From: Paul Cann
Sent: 30 October 2017 16:13
To: Planning.Responses
Subject: RE: Planning Consultation on: AL/115/17/OUT

Engineers comments in respect to surface water drainage:

APPLICATION AL/115/17/OUT

Site Address: Wings Nursery Lidsey Road Aldingbourne PO20 3SU

Drawing Title
Drainage Strategy

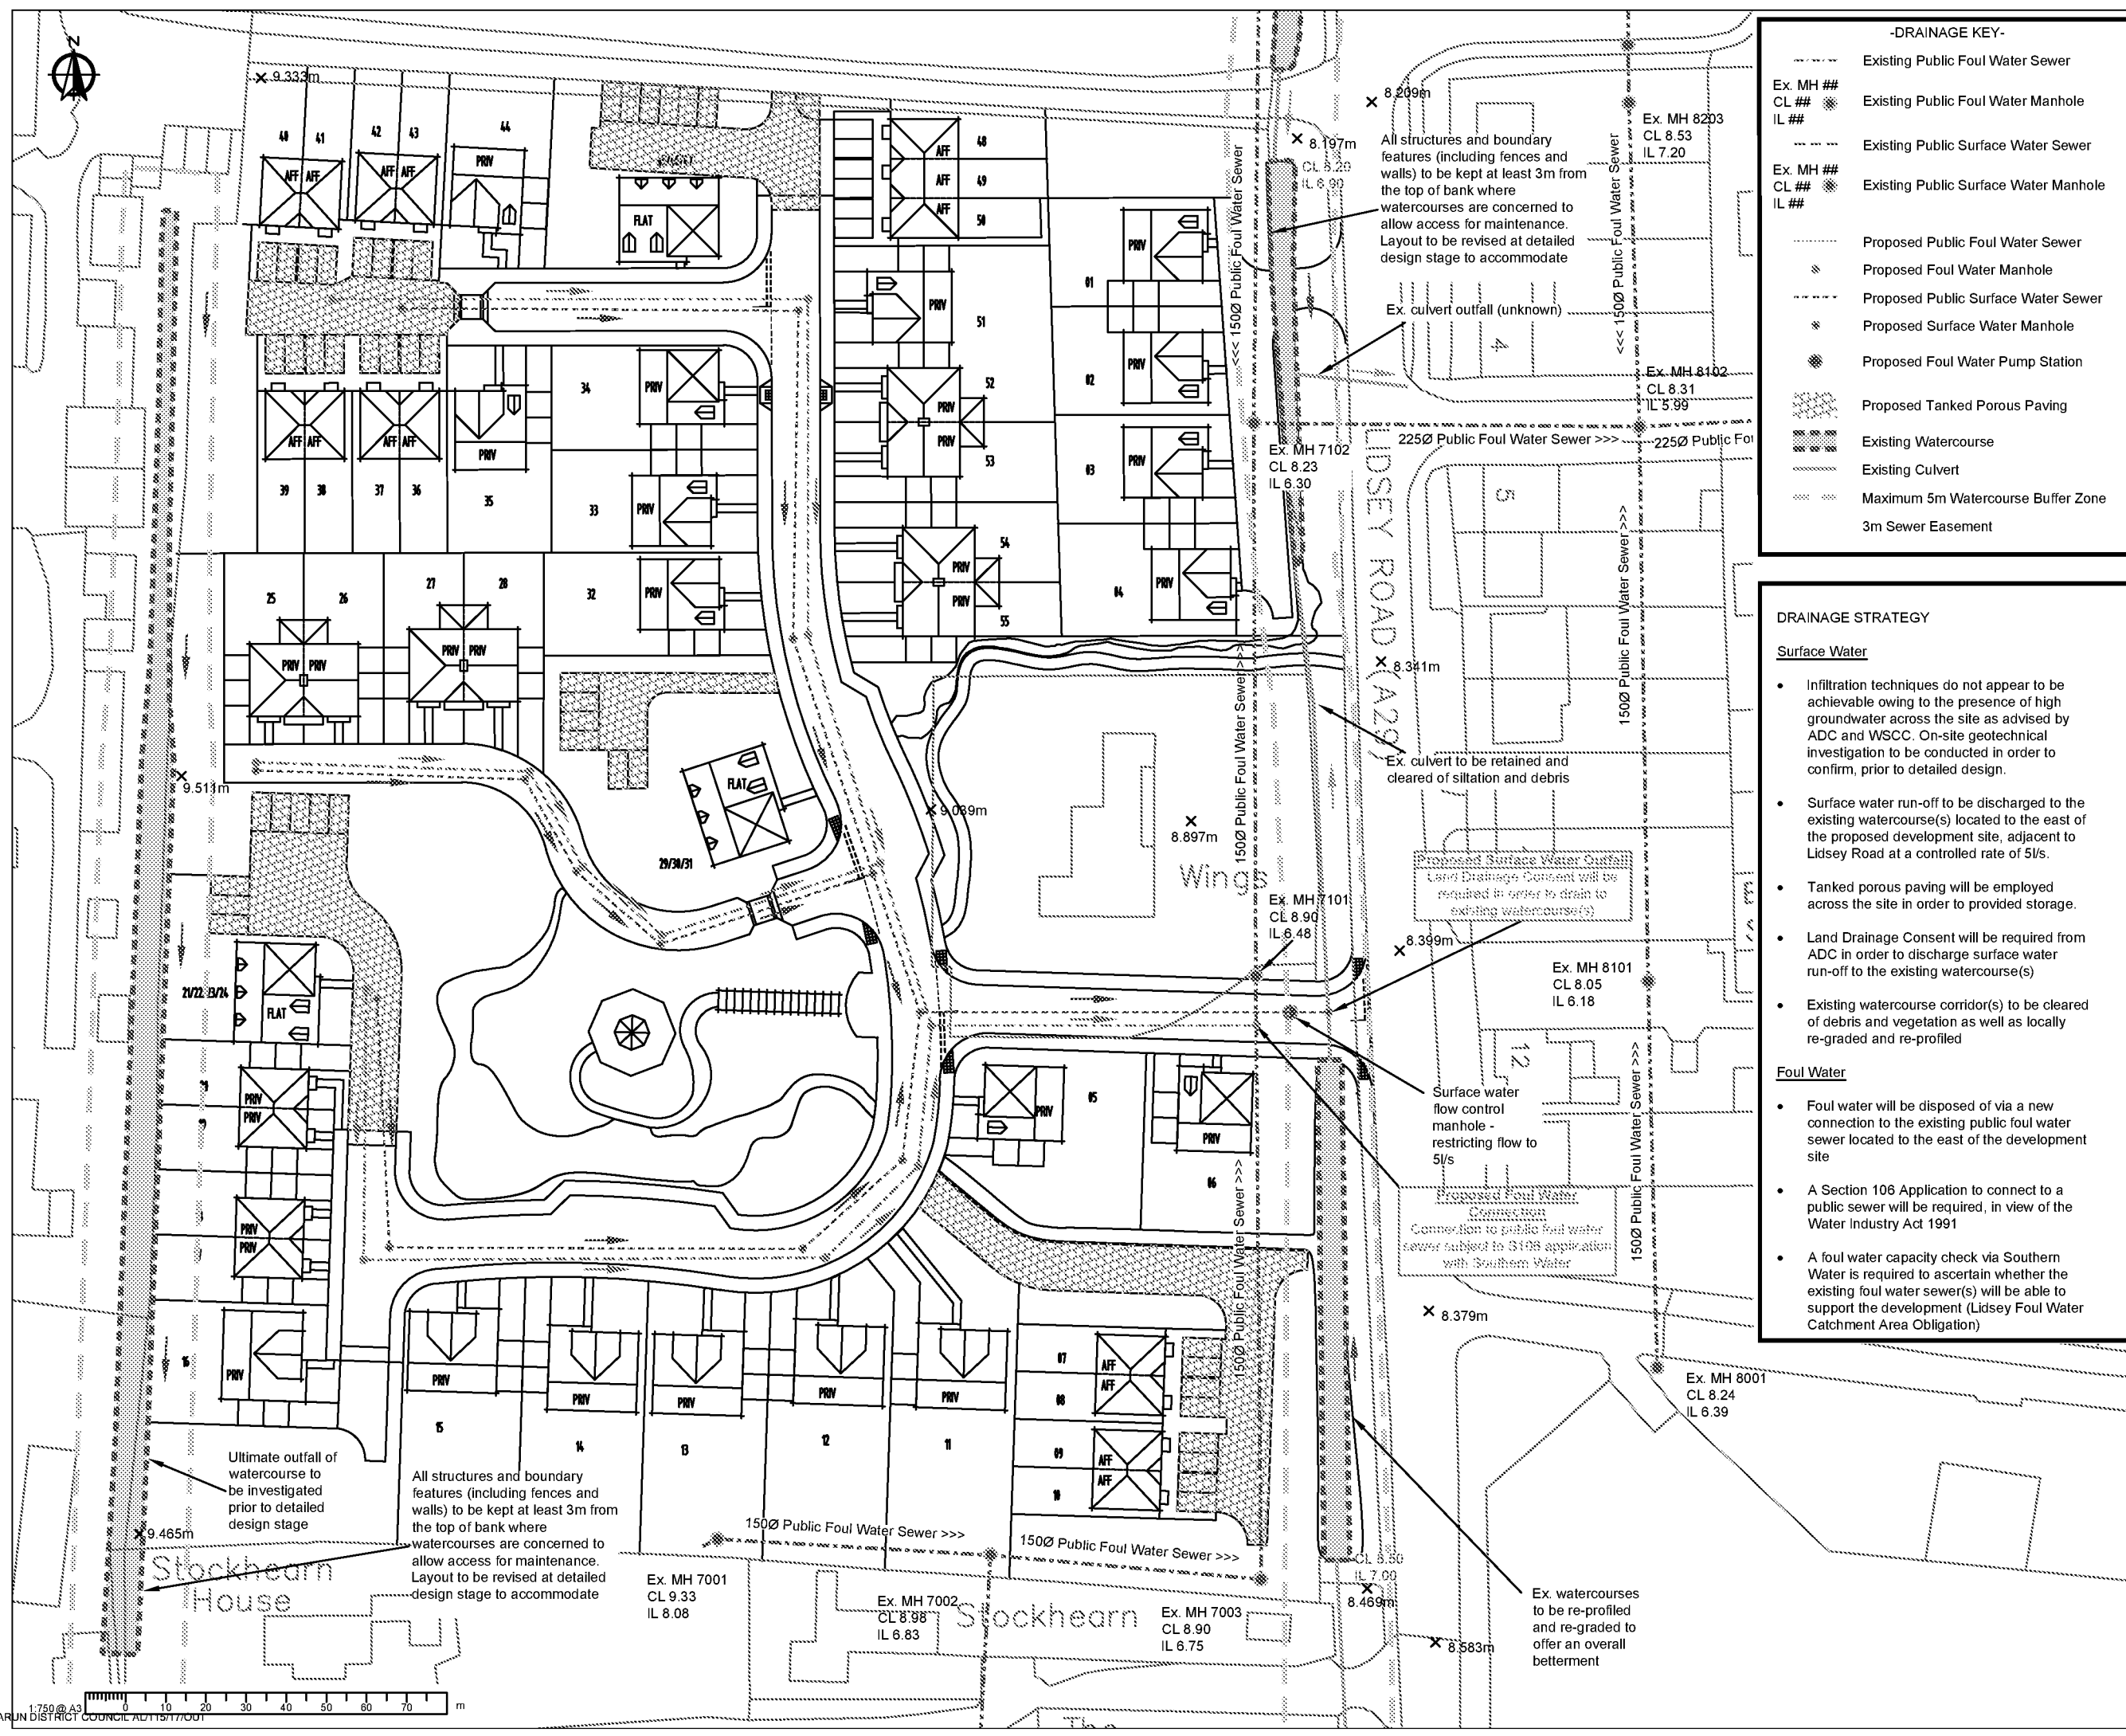
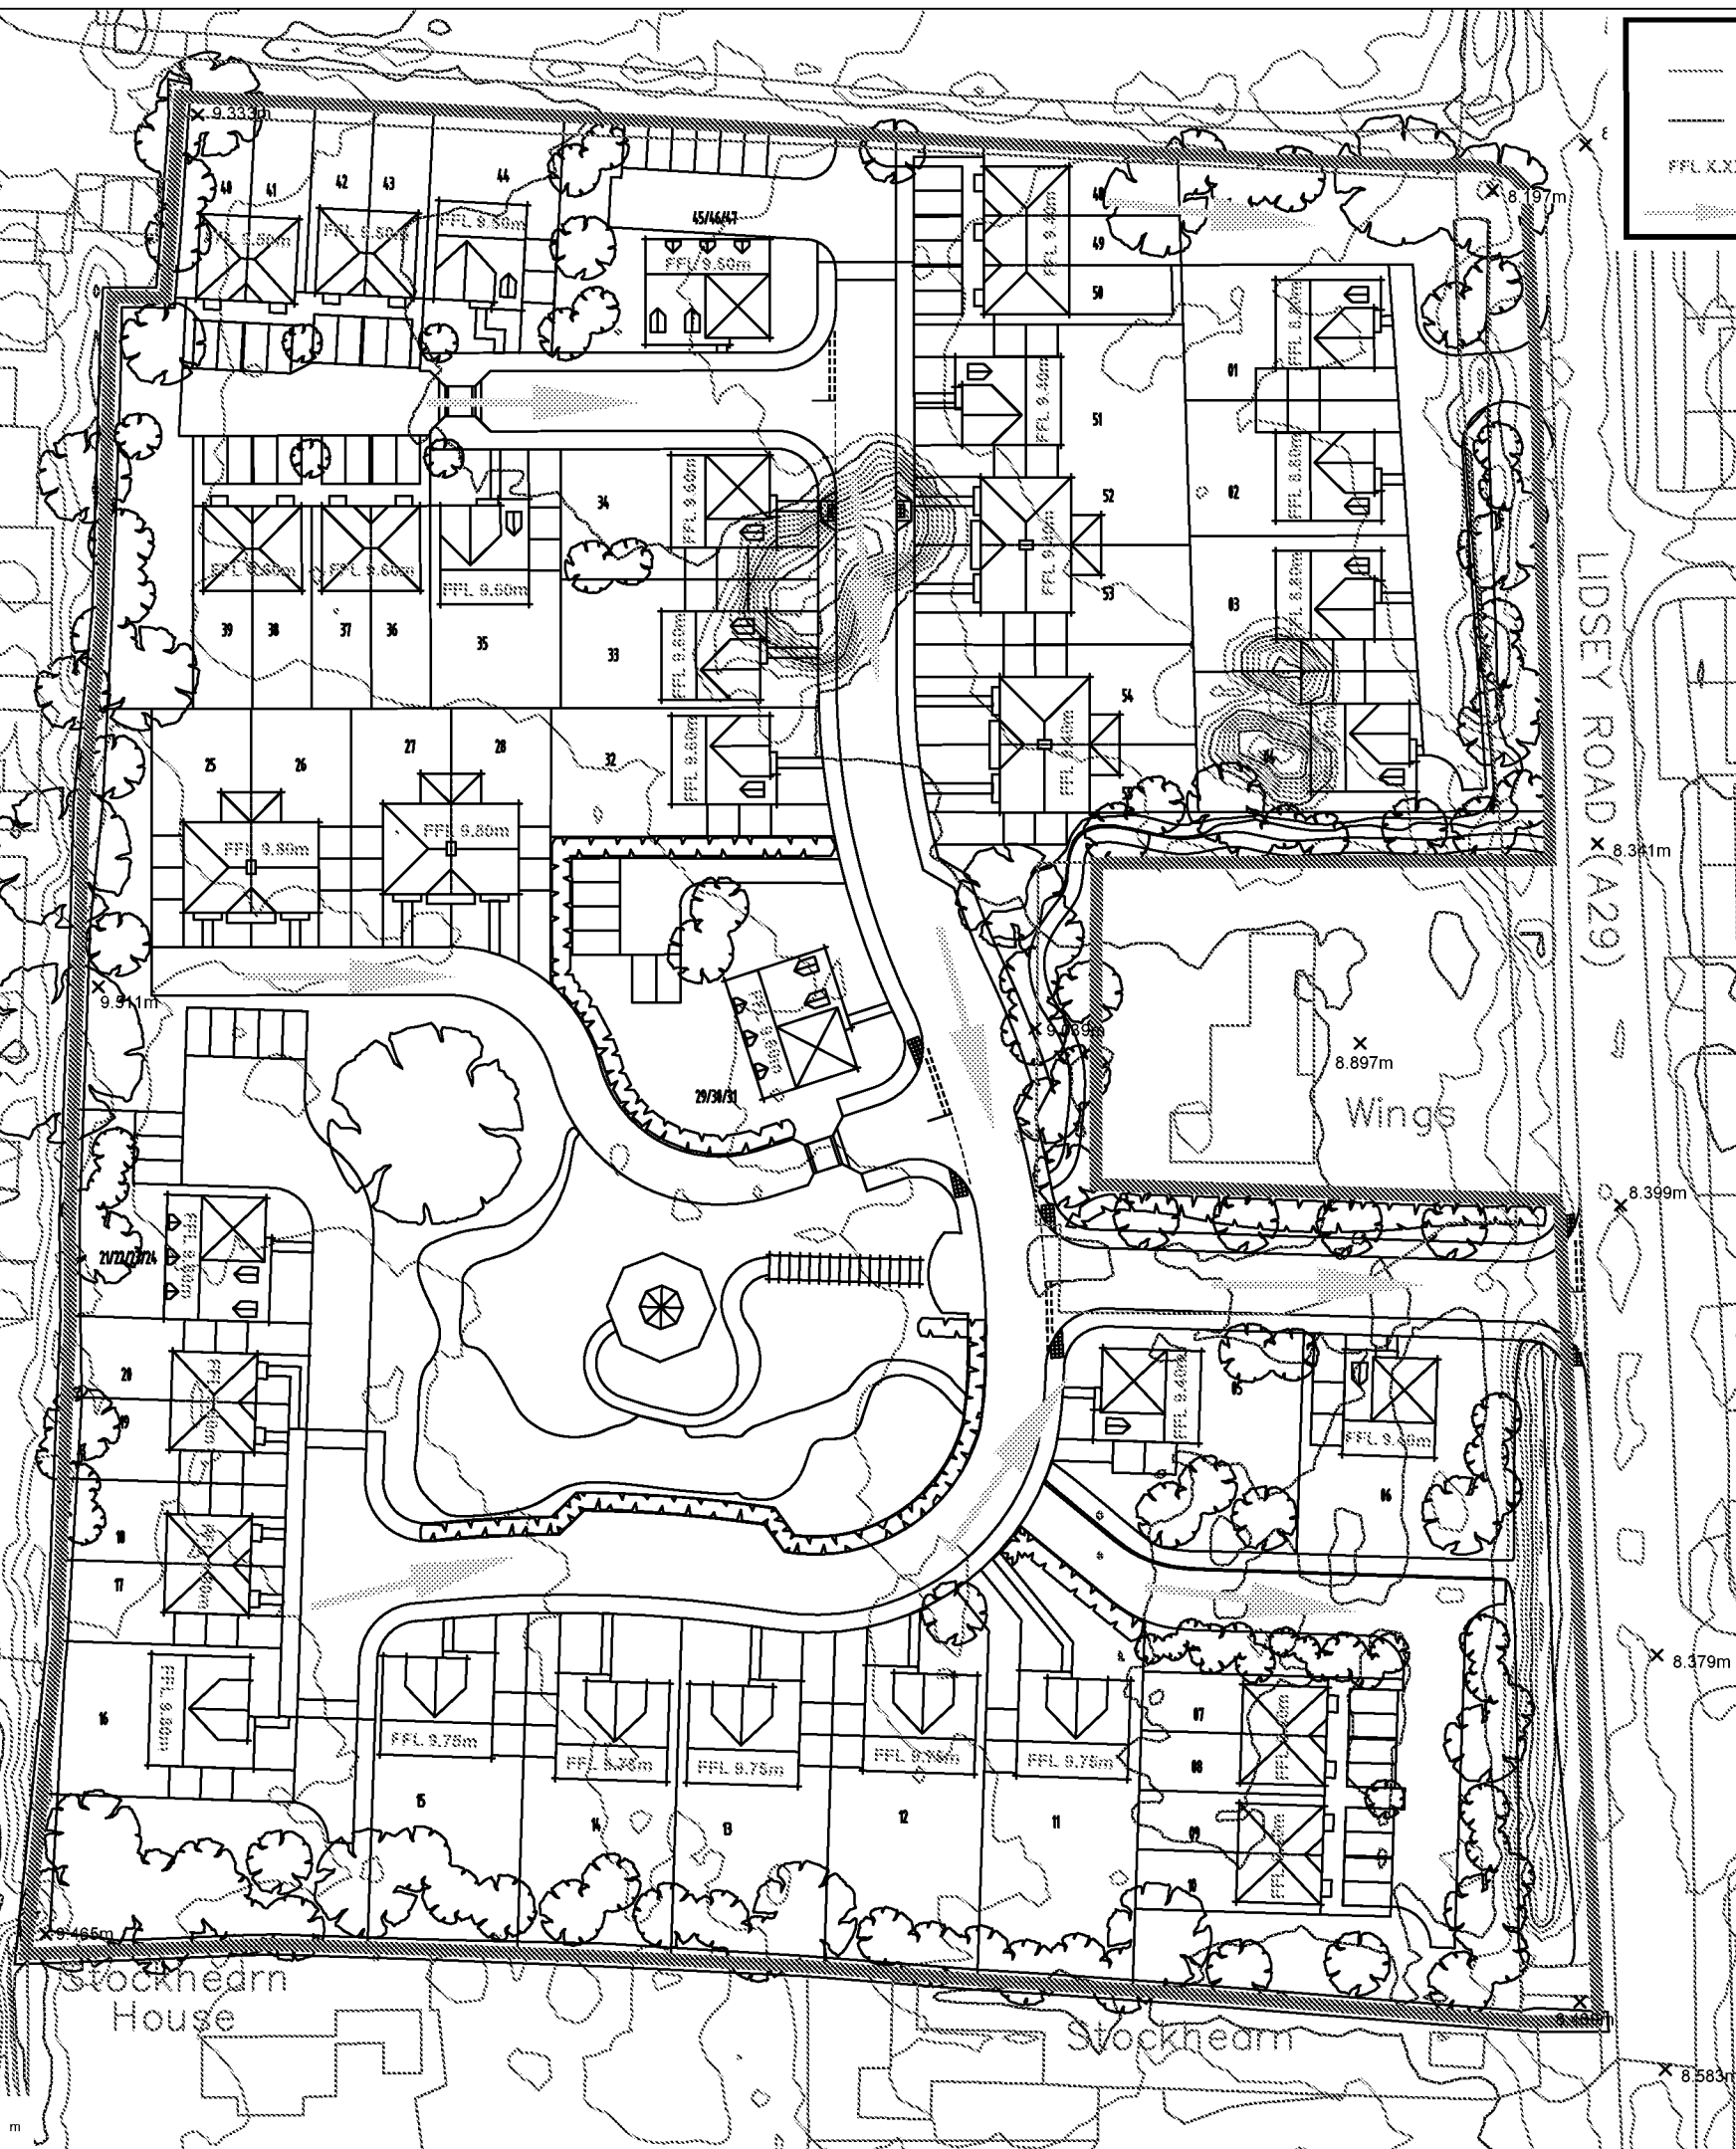
The proposed layout seems to imply that the applicant is proposing to discharge to the watercourse on the eastern boundary, however, the use of infiltration structures must be fully investigated before being dismissed.

Infiltration rates for soakage structures are to be based on percolation tests undertaken in the winter period and at the location and depth of the proposed structures. The percolation tests must be carried out in accordance with BRE 365, CIRIA R156 or a similar approved method and cater for the 1 in 10 year storm between the invert of the entry pipe to the soakaway, and the base of the structure. It must also have provision to ensure that there is capacity in the system to contain below ground level the 1 in 100 year event plus 30% on stored volumes, as an allowance for climate change. Adequate freeboard must be provided between the base of the soakaway structure and the highest recorded annual groundwater level identified in that location. Supplementary guidance notes are also enclosed for information.

Improvements/maintenance to existing watercourses, both adjacent to the site and possibly downstream, are likely to be required, to ensure the free flow of water (if a discharge to the watercourse is ultimately required), and to fulfil the landowners riparian responsibilities.

There is also believed to be a watercourse on the western boundary. The applicant will need to investigate where this watercourse ultimately outfalls, as it may pass through the development site and therefore may impact on the layout. The proposed development layout also does not fully consider access for maintenance of the western boundary ditch ie. ensuring all structures/boundary fences are kept at least 3 metres from the top of the ditch bank, etc.

Any culverting of the eastern boundary ditch to facilitate the new development access will require Land Drainage Consent.
